Our ref: HA/2019/121220/02-L01
Your ref: M/24/19/PL
Date: 18 April 2019

ADDITIONAL RESPONSE - REPLACEMENT RESIDENTIAL DWELLING. THIS APPLICATION MAY AFFECT A PUBLIC RIGHT OF WAY.

3 THE HARD ELMER PO22 6JS

SITE TOPOGRAPHICAL SURVEY

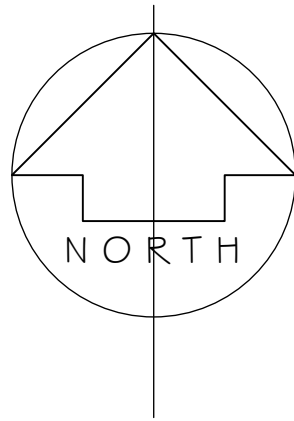
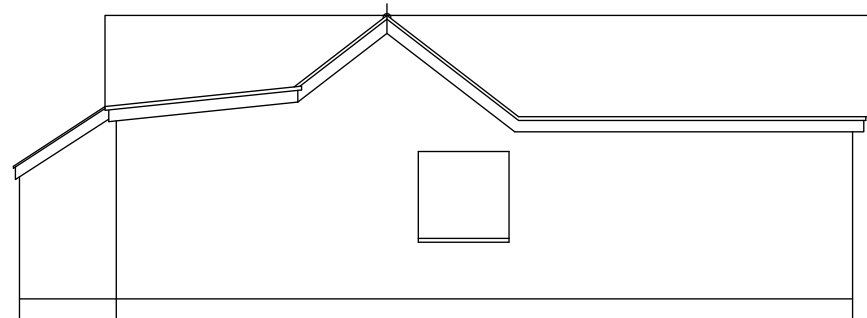
We have responded on the 18 April (our ref HA/2019/121220/01) with suggested conditions for flood risk. However, upon further review of the bund within the garden we would also request the below condition also be attached to any permission granted:

No reduction in the height of the secondary flood bund will be undertaken.
